CITY OF PORTLAND, MAINE

March 29, 2018

Project Name:	Parris Terraces	Project ID:	2017-287 and 2017-297 (IZ)
Address:	60 Parris Street	CBLs:	33-A-13
Applicant:	City of Portland		
Planner:	Nell Donaldson

Parris Terraces, 60 Parris Street
Level III Subdivision and Conditional Use Review
2017-287
Horton LLC

SITE PLAN

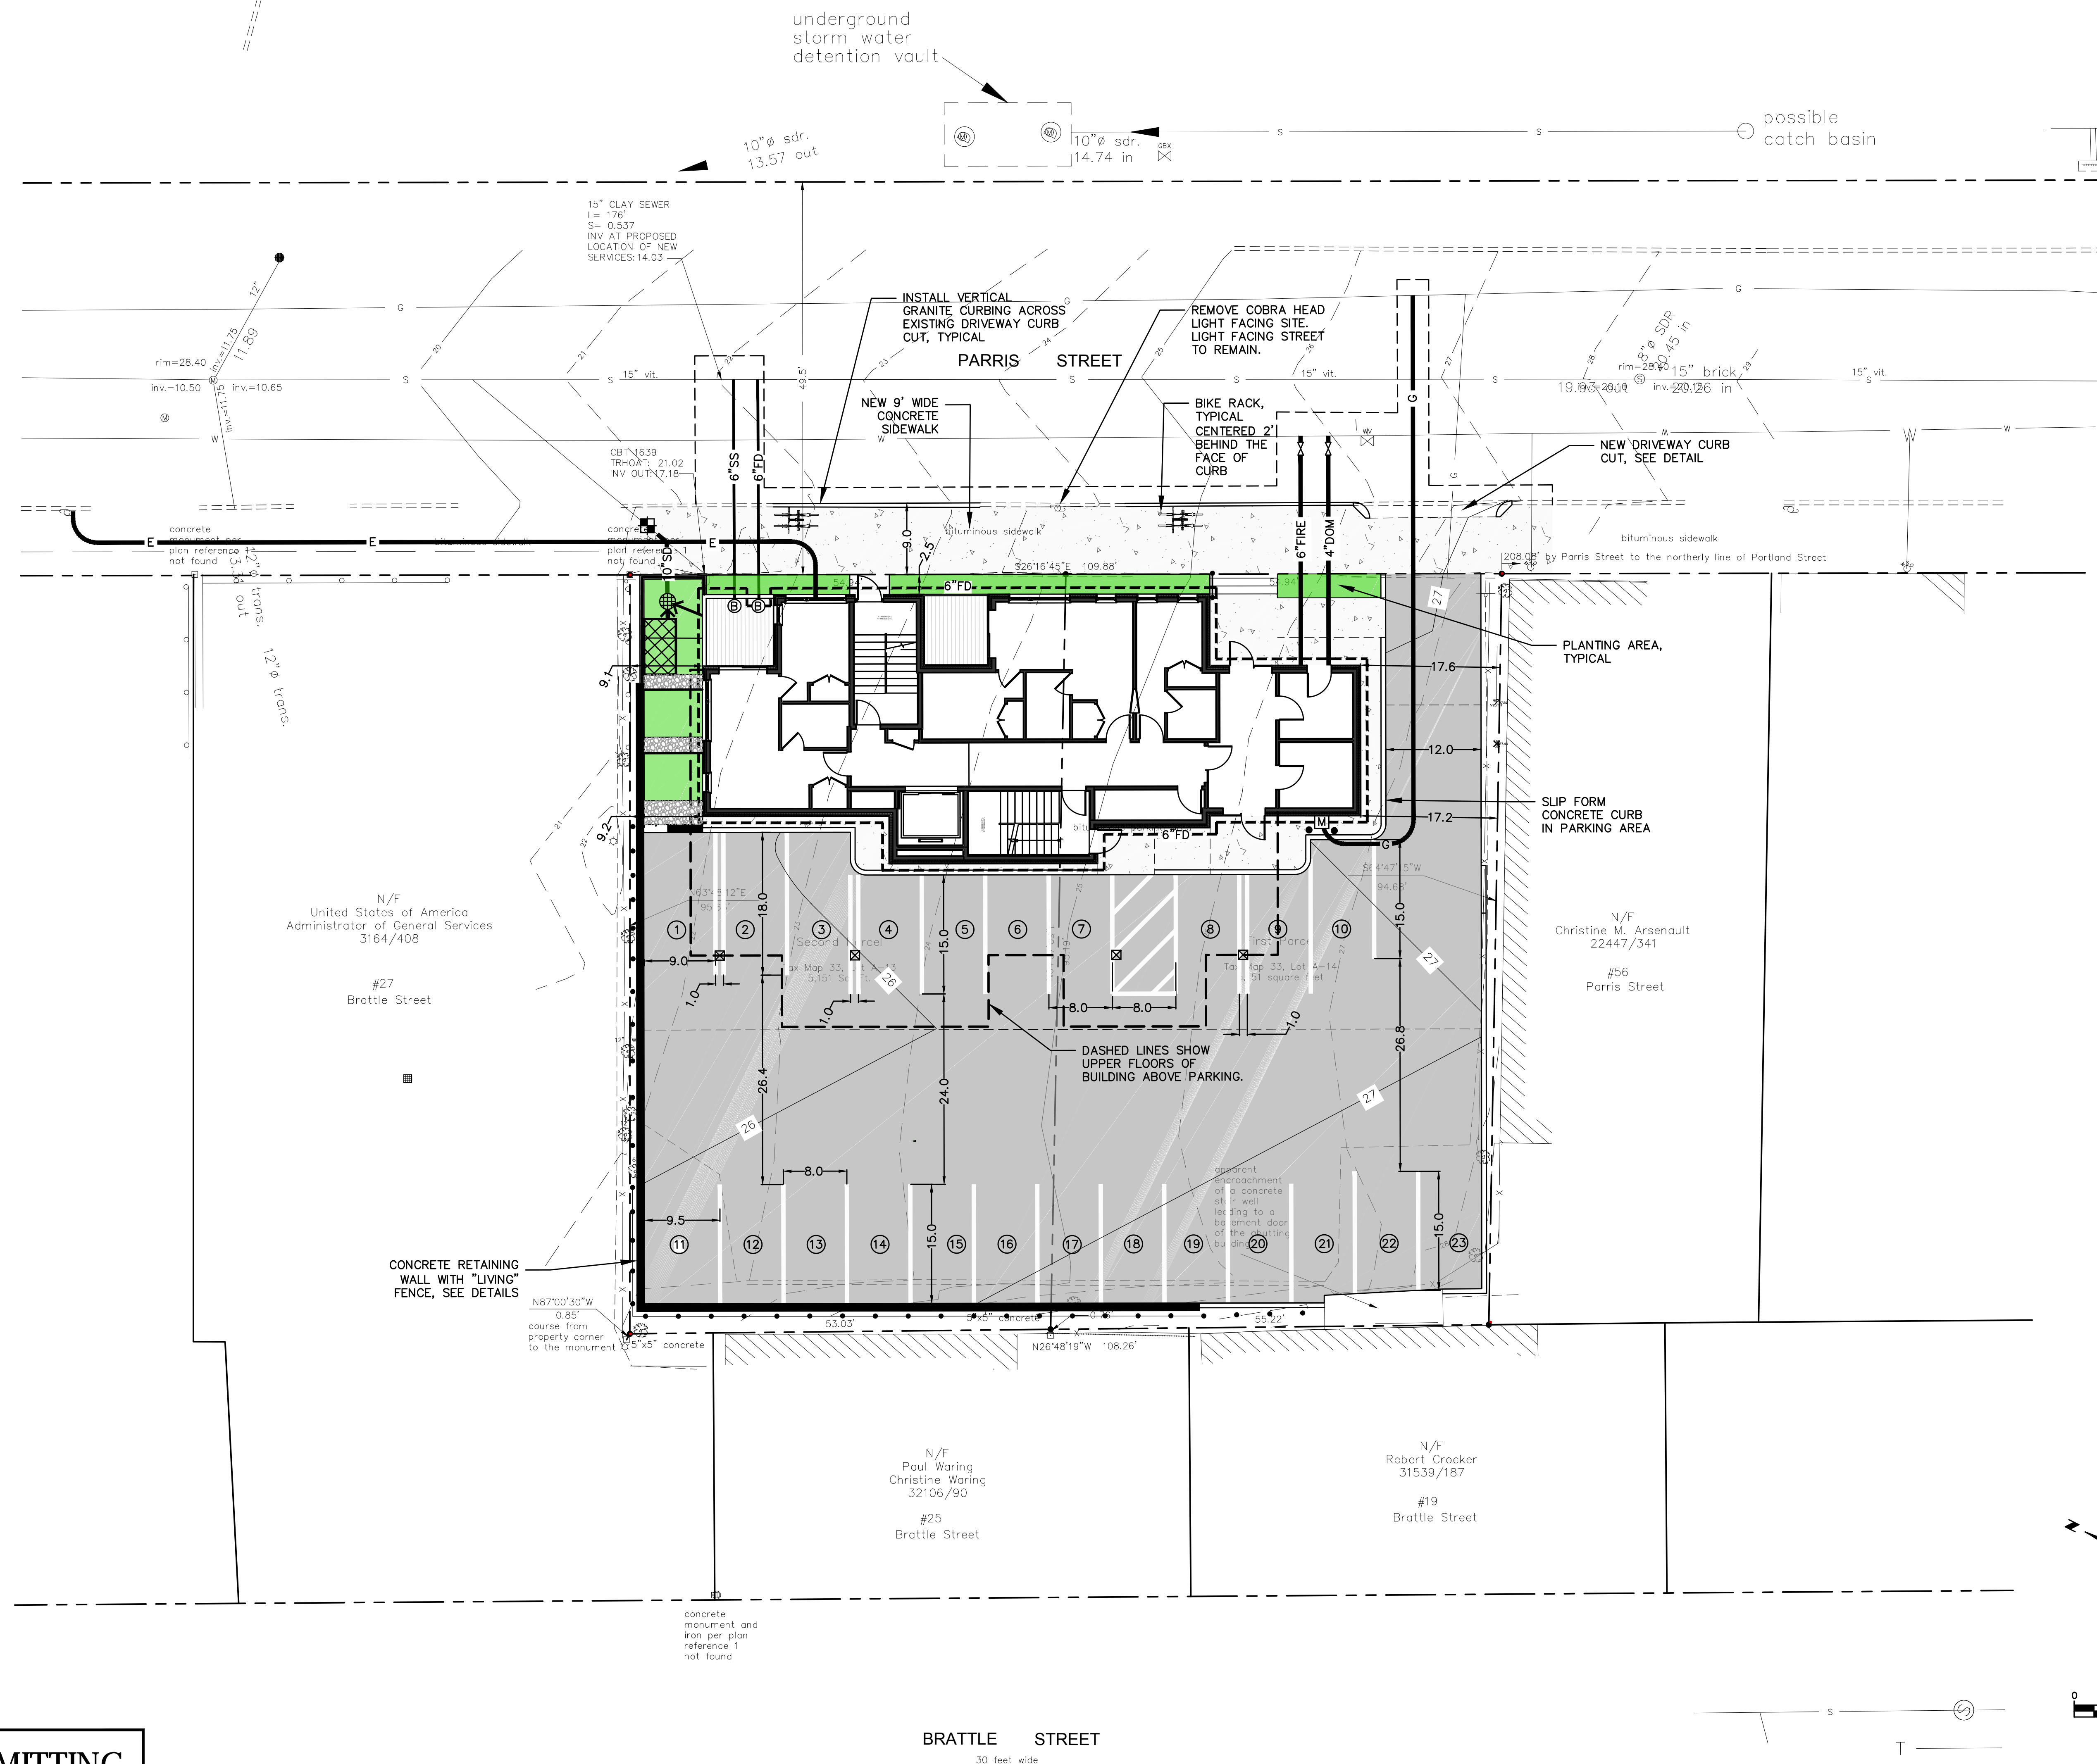
In response to staff comments, the applicant has increased the driveway width at the southern end of the site to 15.2'. The northerly edge of this driveway is proposed with flush concrete pavers as a means of differentiating a pedestrian way along the edge of the building.

The plans have been revised to provide a 15.2 foot wide driveway entrance that will function as a shared driveway (pedestrian facility will be flush). As noted previously, the project site would be expected to generate very low traffic volumes and during peak time periods traffic will primarily either be entering the site (returning home) or exiting the site (leaving home). During the morning peak hour, approximately 8 vehicles would be expected to exit the site and 2 vehicles will enter the site. This corresponds to one vehicle every 6 minutes. During the afternoon peak hour, about 8 vehicles would be expected to enter the site and 4 vehicles exit. This corresponds to one vehicle every 5 minutes. Given vehicle movement infrequency, the likelihood that trip levels will be less given the urban location, and low traffic volumes on Parris Street, I support a waiver from the minimum driveway width standard of 20 feet.

The proposed driveway does not meet City standards as it relates to driveway separation. Given that the non-conformity is an existing condition, the abutting driveway is to a single vehicle driveway, and traffic volumes are relatively low on Parris Street, I support a waiver from the City's Technical standards.

A new 9 foot concrete sidewalk is proposed along Parris Street. In the final plans, the applicant has shown 4.5 feet of clearance around the street trees proposed in the sidewalk, and has added limits of sidewalk construction. The sidewalk material is shown on the site plan as reinforced concrete, which conforms to the city's material policy for Parris Street. Documentation regarding accessible routes to the main entrance and from the parking area has also been added to the plans.

INLET PROTECTION - SILT SACK

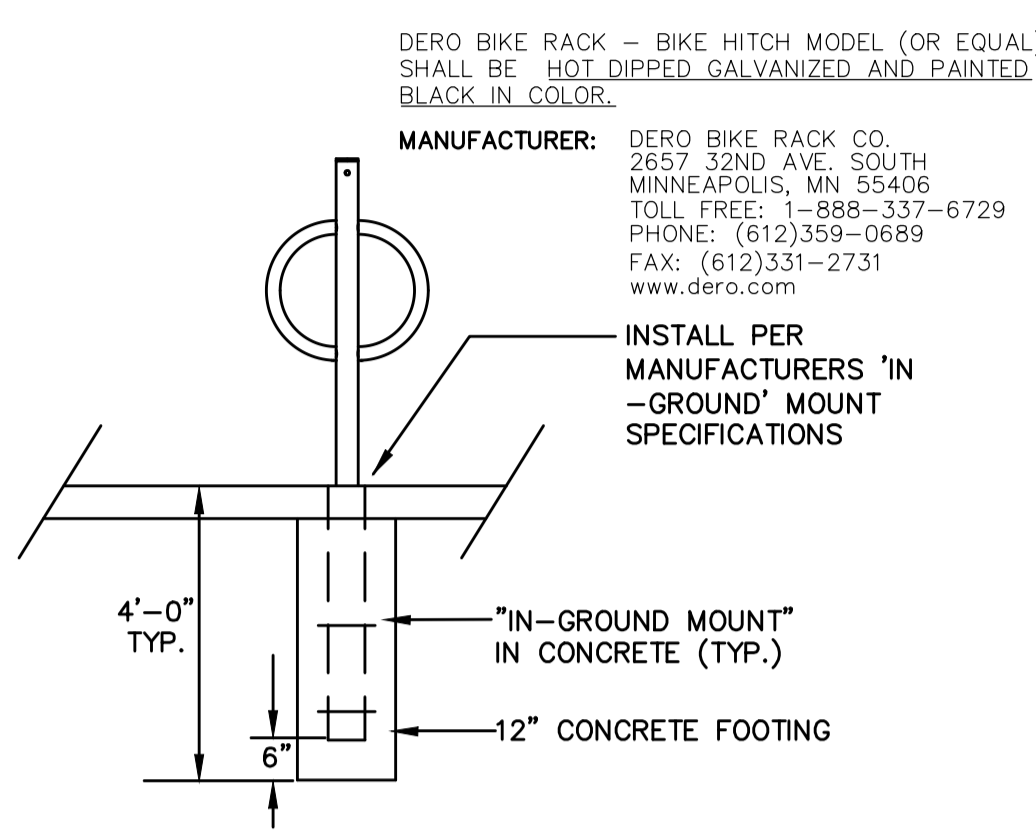
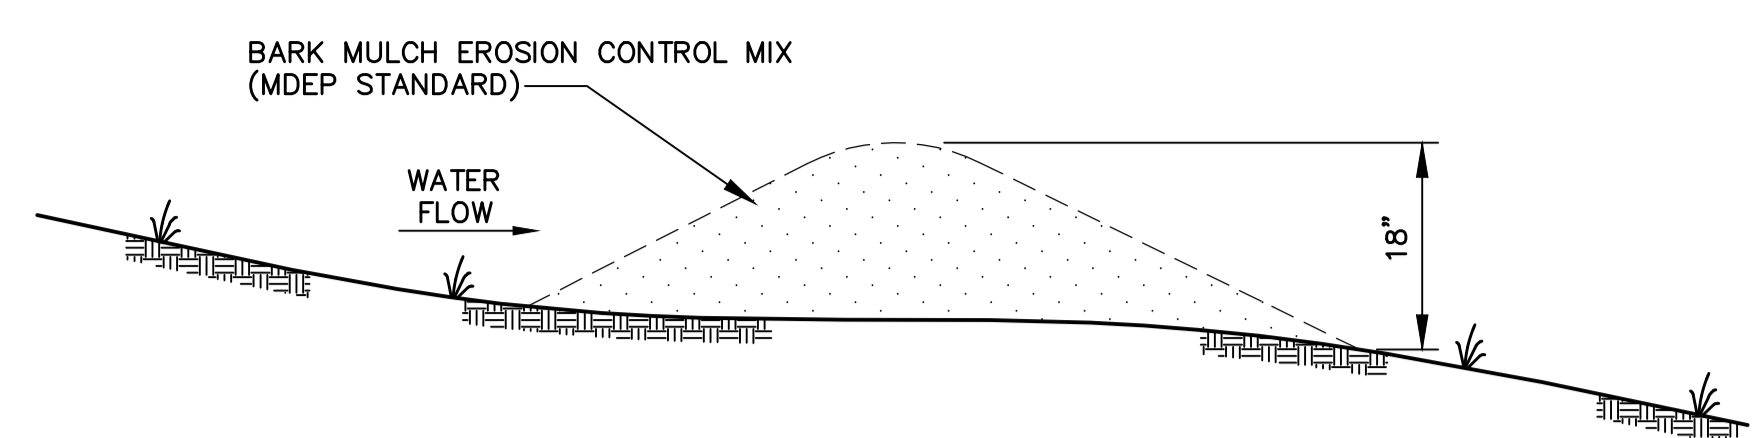
- *In the Stormwater Management Narrative, the Applicant indicates erosion control measures are described on Sheet C-1 with details on C-4. However, no erosion control measures are specifically identified on the plan.*
- *A construction erosion and sedimentation control plan that addresses erosion and sediment control requirements, inspection and maintenance requirements, and good housekeeping practices should be included in the plan set.*

- a. Provide final plans, notes, and details that address erosion and sediment control requirements, inspection and maintenance requirements, and good housekeeping practices in accordance with the final review provided by the city's consulting civil engineer (*Attachment 3*), and

WEATHERING STEEL RETAINING WALL, SCHEMATIC DETAIL

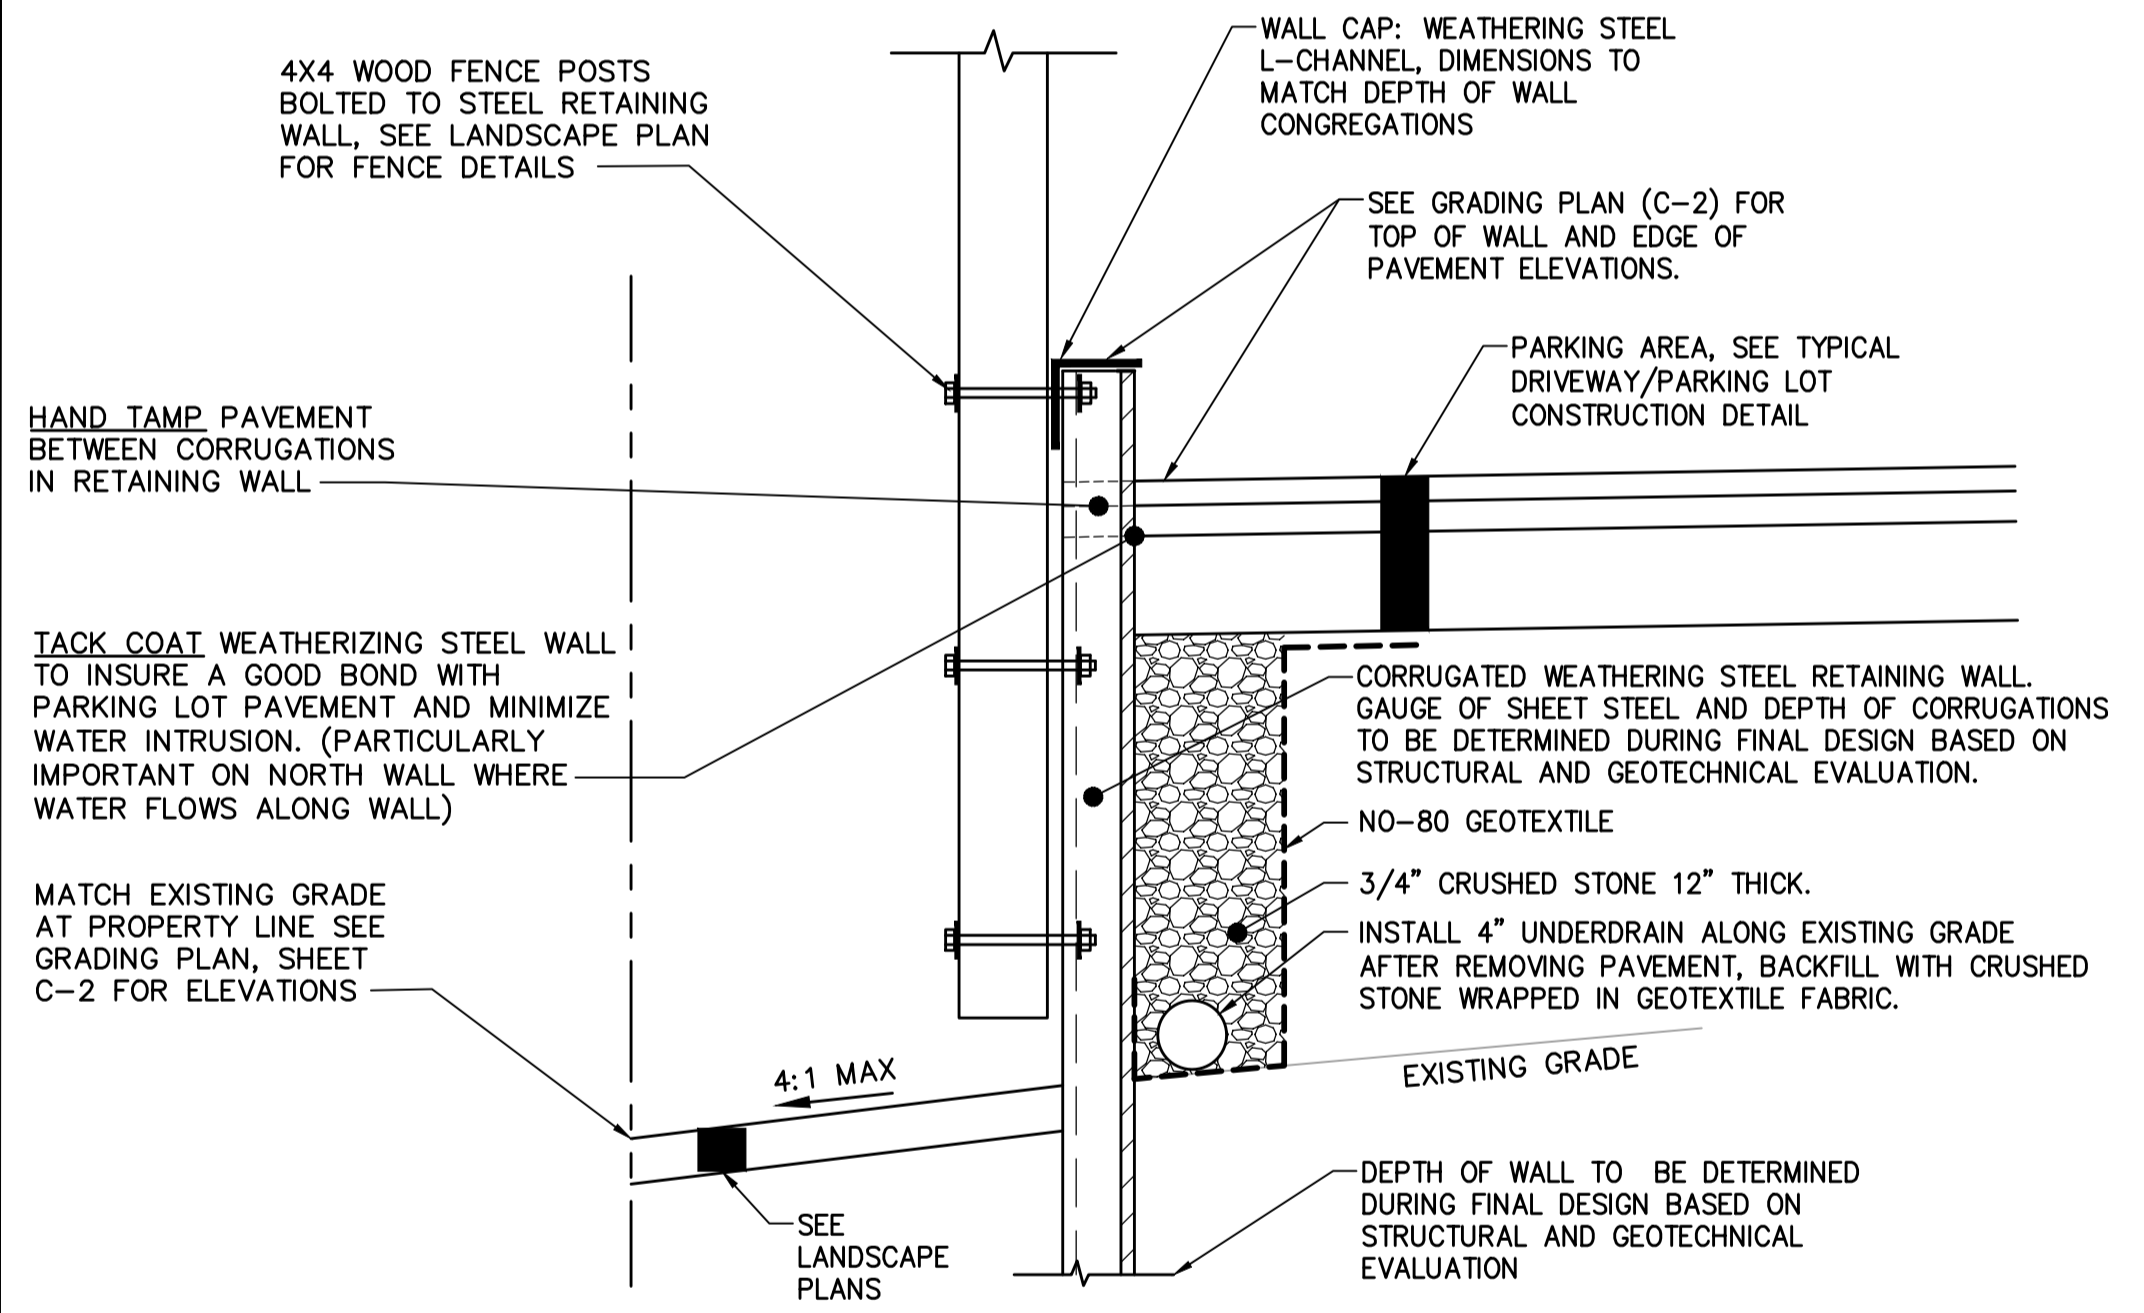
A retaining wall is proposed around a portion of the site and a geotechnical evaluation has been conducted. A note on the Grading, Drainage and Stormwater Plan (Sheet C-2) references structural and landscaping details for the proposed retaining wall, but it appears that no structural details have been submitted. Please provide structural details for the proposed retaining wall.

5. The applicant shall revise the site plan set to:
 - a. Eliminate 'bituminous sidewalk' labels in existing conditions layers;
 - b. Provide structural details for the proposed retaining wall; and
